Application for Proposed Alterations to Listed Buildings Consent 6/2019/0218/LB at Northaw House, Northaw

I have today submitted an application pursuant to S19 of the Planning (Listed Buildings and Conservation Areas) Act 1990, seeking an altered listed building permission for residential development at Northaw House, in relation to the approved plans under Condition 4, relating to application 6/2019/0218/LB, as amended by 6/2020/0930/VAR.

The Applicant, LW Developments, wishes to make some minor changes to the approved new-build houses in a part of the site referred to within the application documents as the "settlement area". The changes proposed by this application relate firstly to windows and doors on plots 21-26, secondly to the layout of plots 24 and 25 and lastly the access arrangement around the "settlement area" and the layout of car parking spaces. The table below sets out the proposed changes:

Scale	A1	Date	07/01/2021
1:50	A3	Checked	DR
1:100			
Drawn			
BW			
Drawing Number	Revision		
8250-SAU-SU1-0011-DR-A	P2

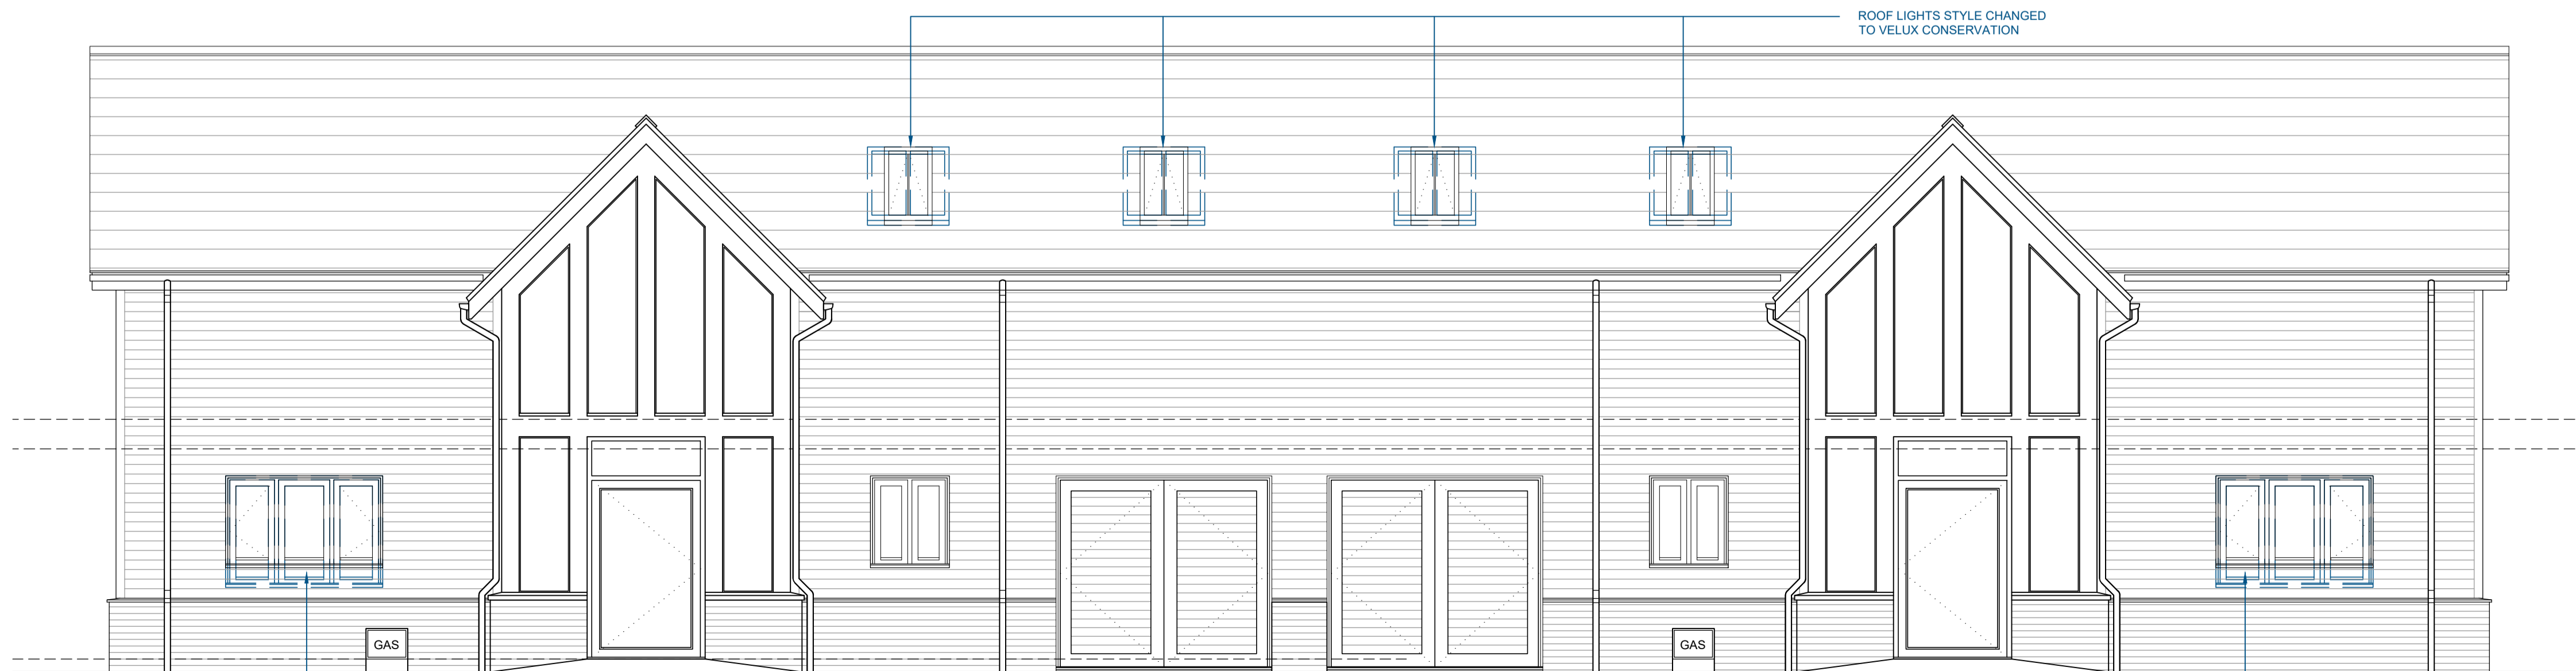
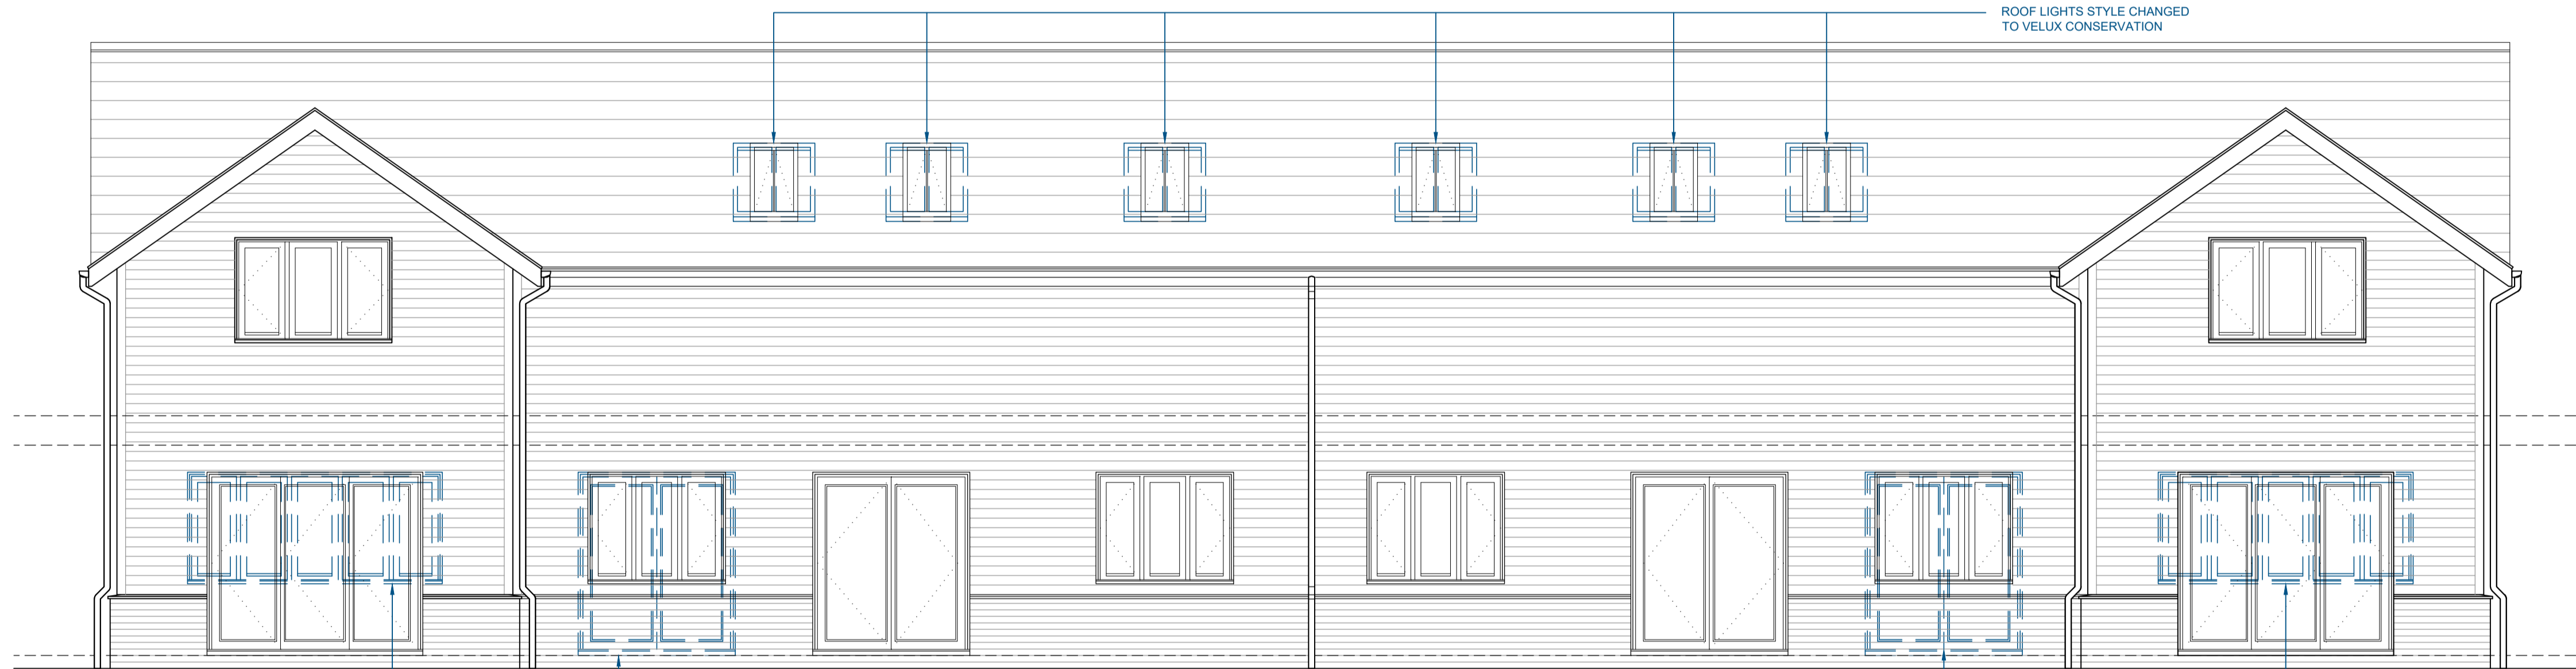
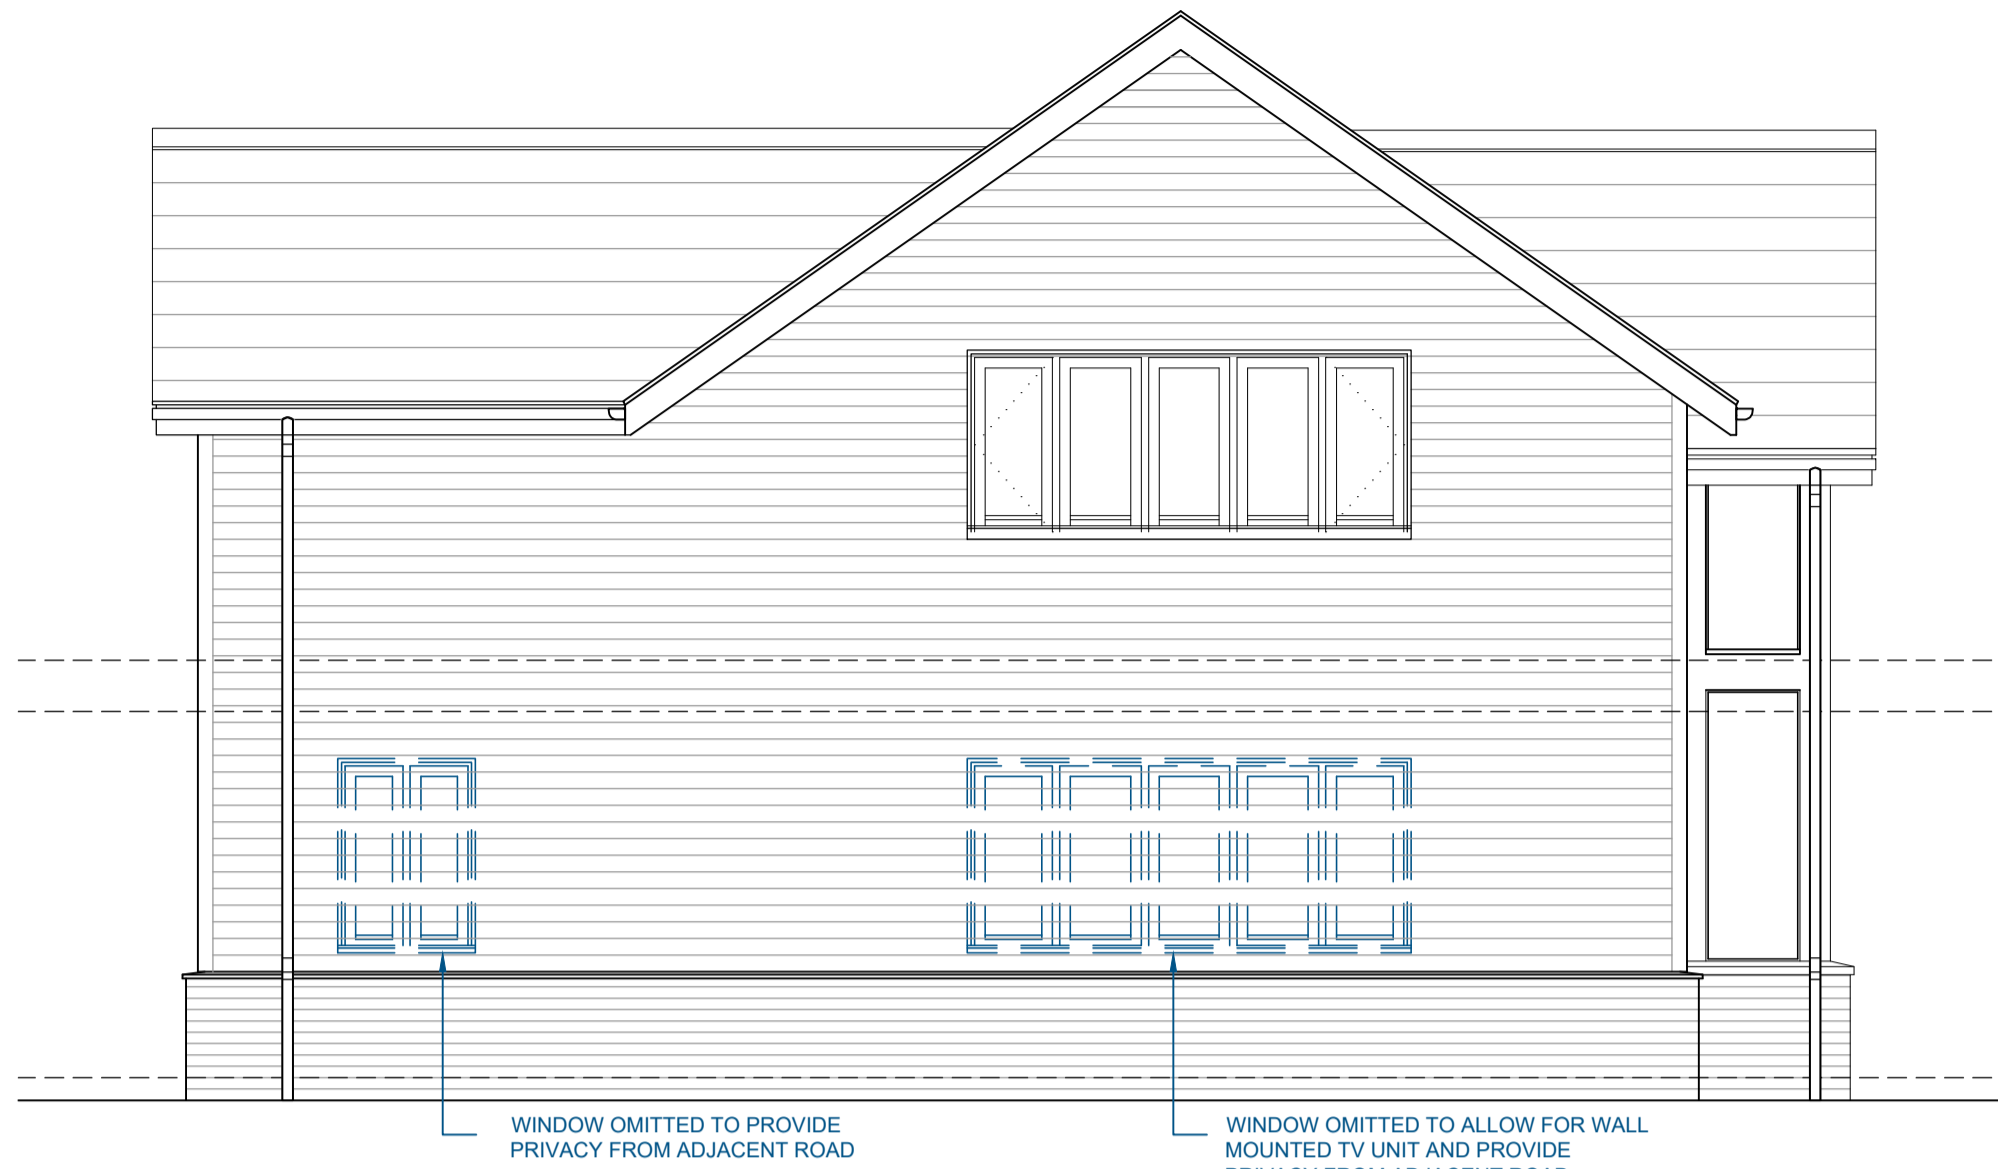
House / Location	Change Proposed	Reason	Previously Approved Drawing Numbers (to be replaced)	Drawing Numbers of the New Proposals
Settlement Unit 1 (Plots 21, 22 and 23)	Raised window cill on front elevation.	To accommodate the kitchen worktop level.	16_254_PL61C	8250-SAU-SU1-1010-DR-A-P2
	Replacement of normal Velux with conservation Velux windows.	To improve the building's appearance.	16_254_PL61C	8250-SAU-SU1-0011-DR-A-P2
